Our Ref: LU/354/19/DOC

Town & Country Planning Act 1990 (as amended)
Town and Country Planning (Development Management Procedure) (England) Order 2015
Approval of details reserved by condition imposed under ref LU/330/18/PL relating to Condition Nos 9 -
periodic verification reports and 15 - electric vehicle charging points.
Land South Of Cornfield Close Littlehampton BN17 6LD

Arun District Council have decided to **REFUSE details reserved by condition for the following reasons:**

REV	DATE	NOTE
DEVELOPMENT		
CORNFIELD CLOSE LITTLEHAMPTON		
DRAWING TITLE		
PARKING PLAN

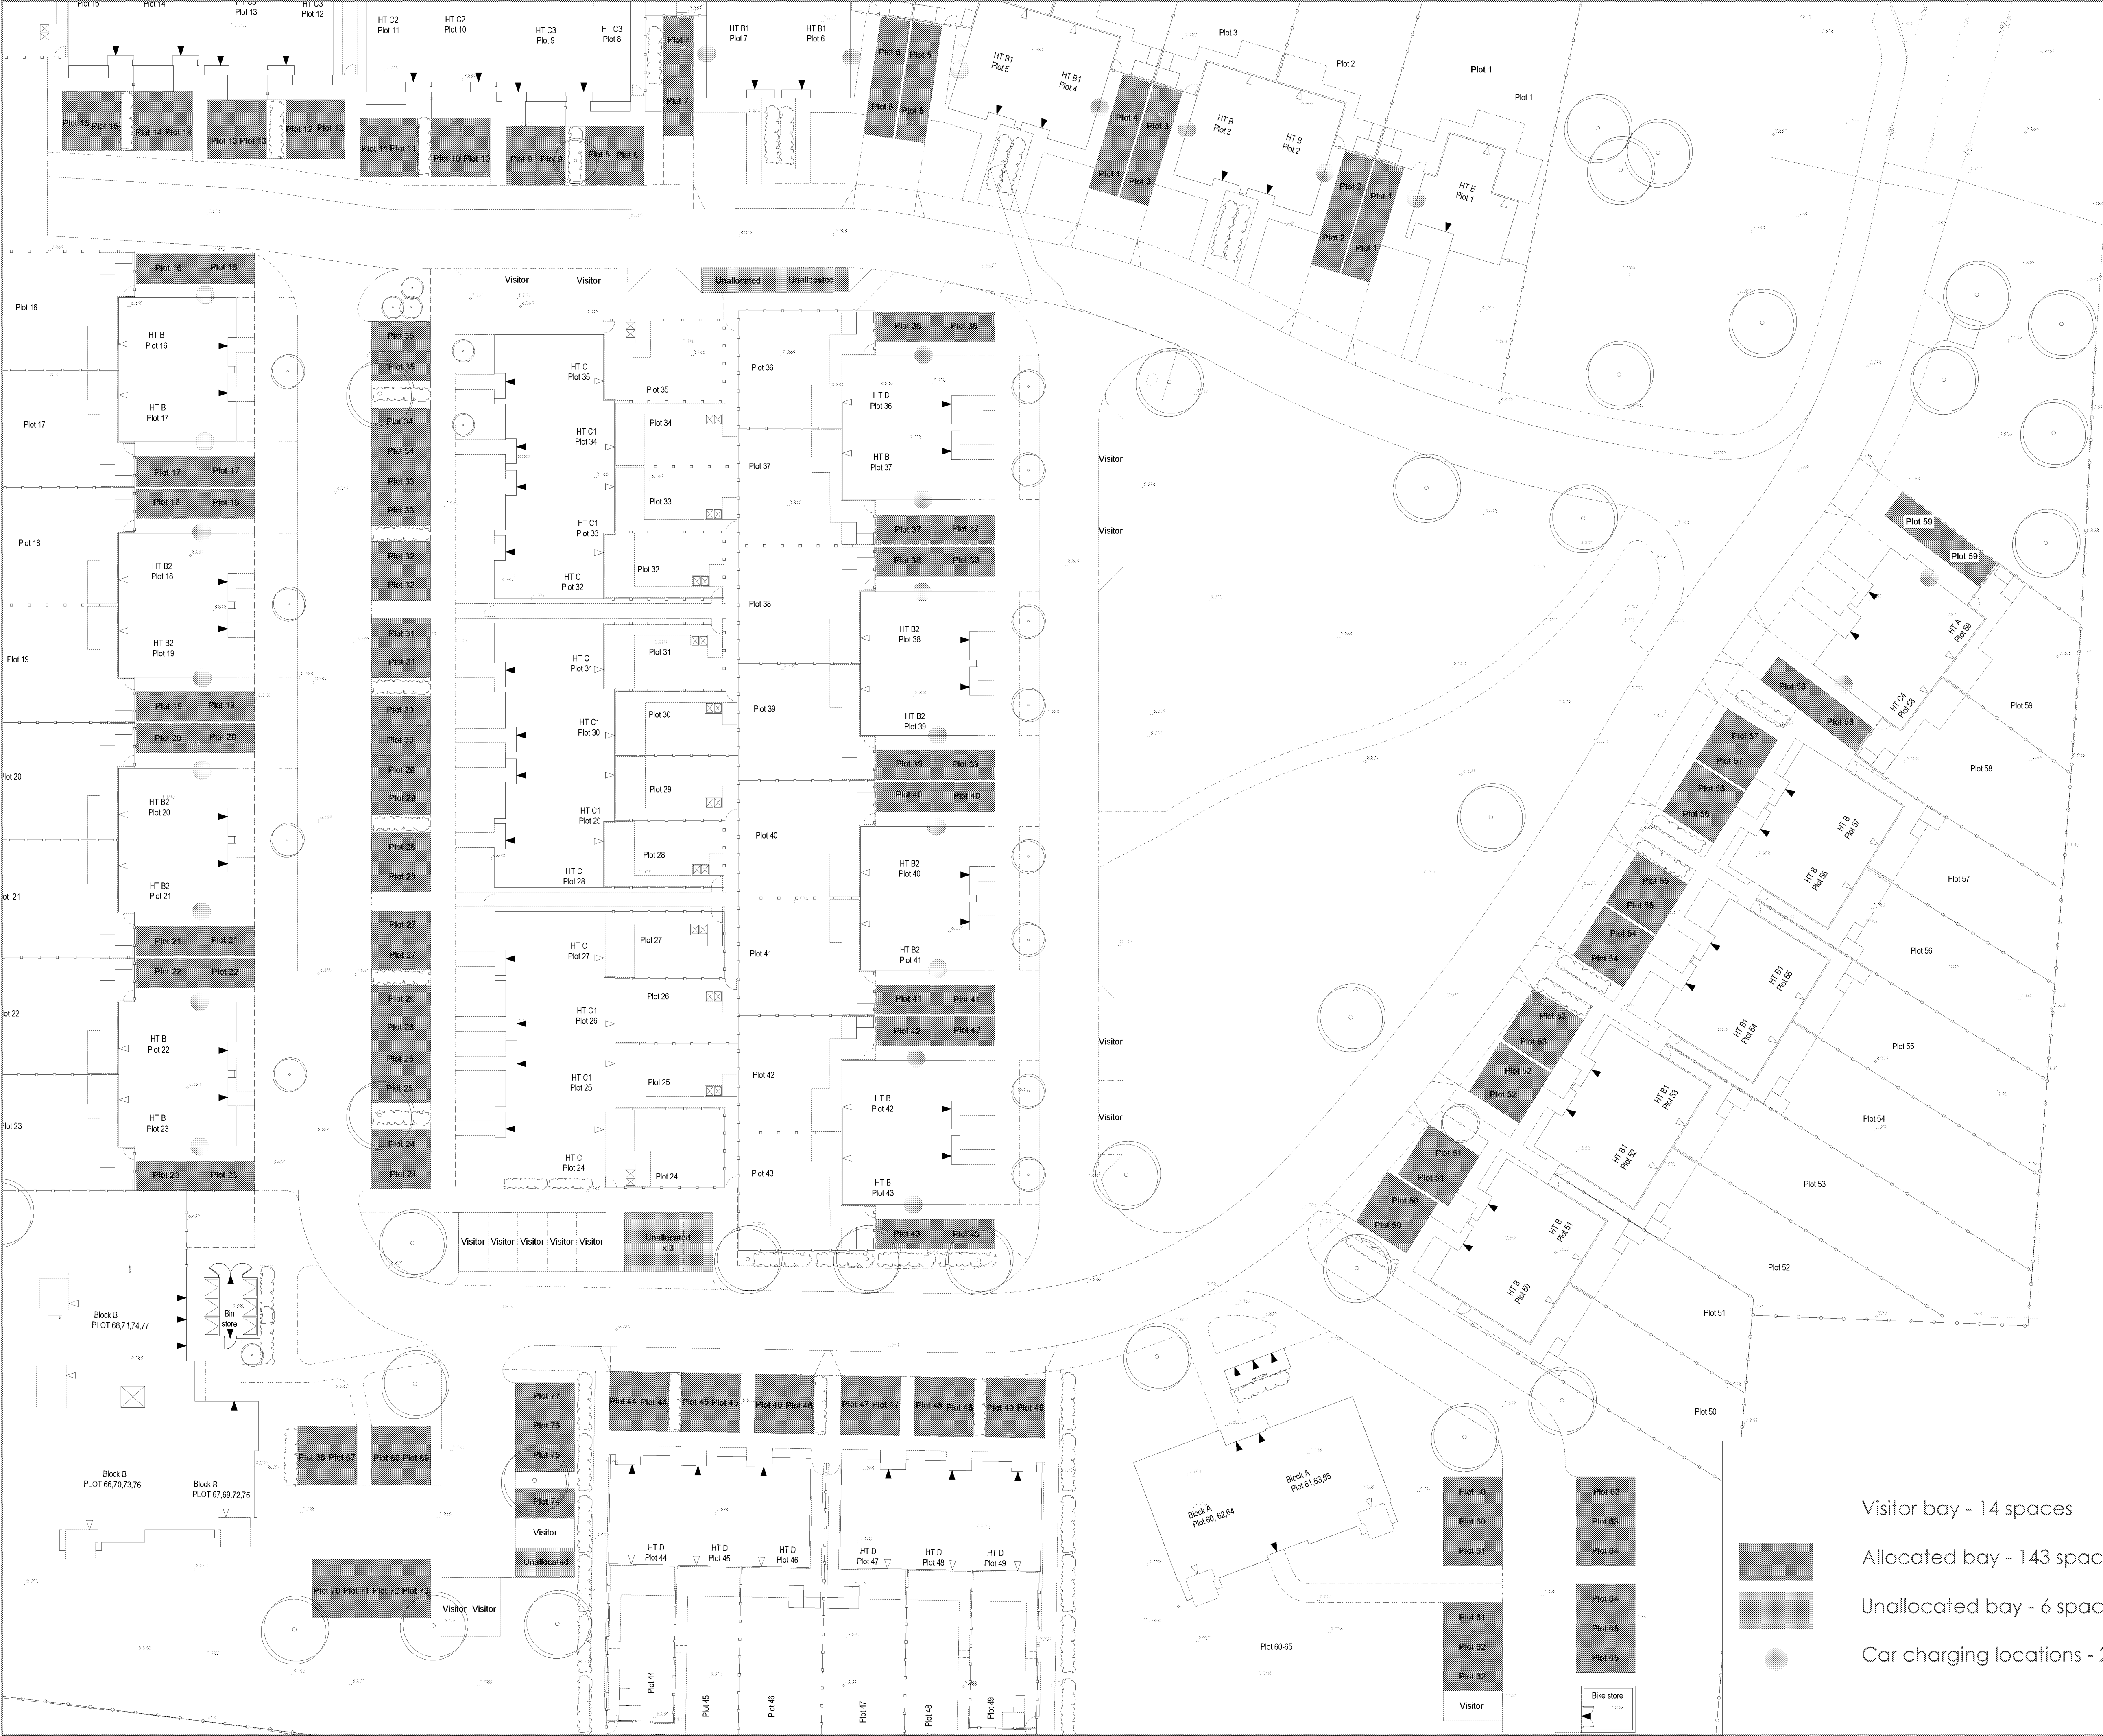
This condition cannot be discharged at this stage..The number of charging points (25) in relation to the number of dwellings (77) Is not adequate. You should provide a scheme (to accompany the submitted plan) of electric vehicle charge points (to include information on how the plan will be implemented, details of accessibility provision(s) and the ratio between occupants/dwellings and charge points).
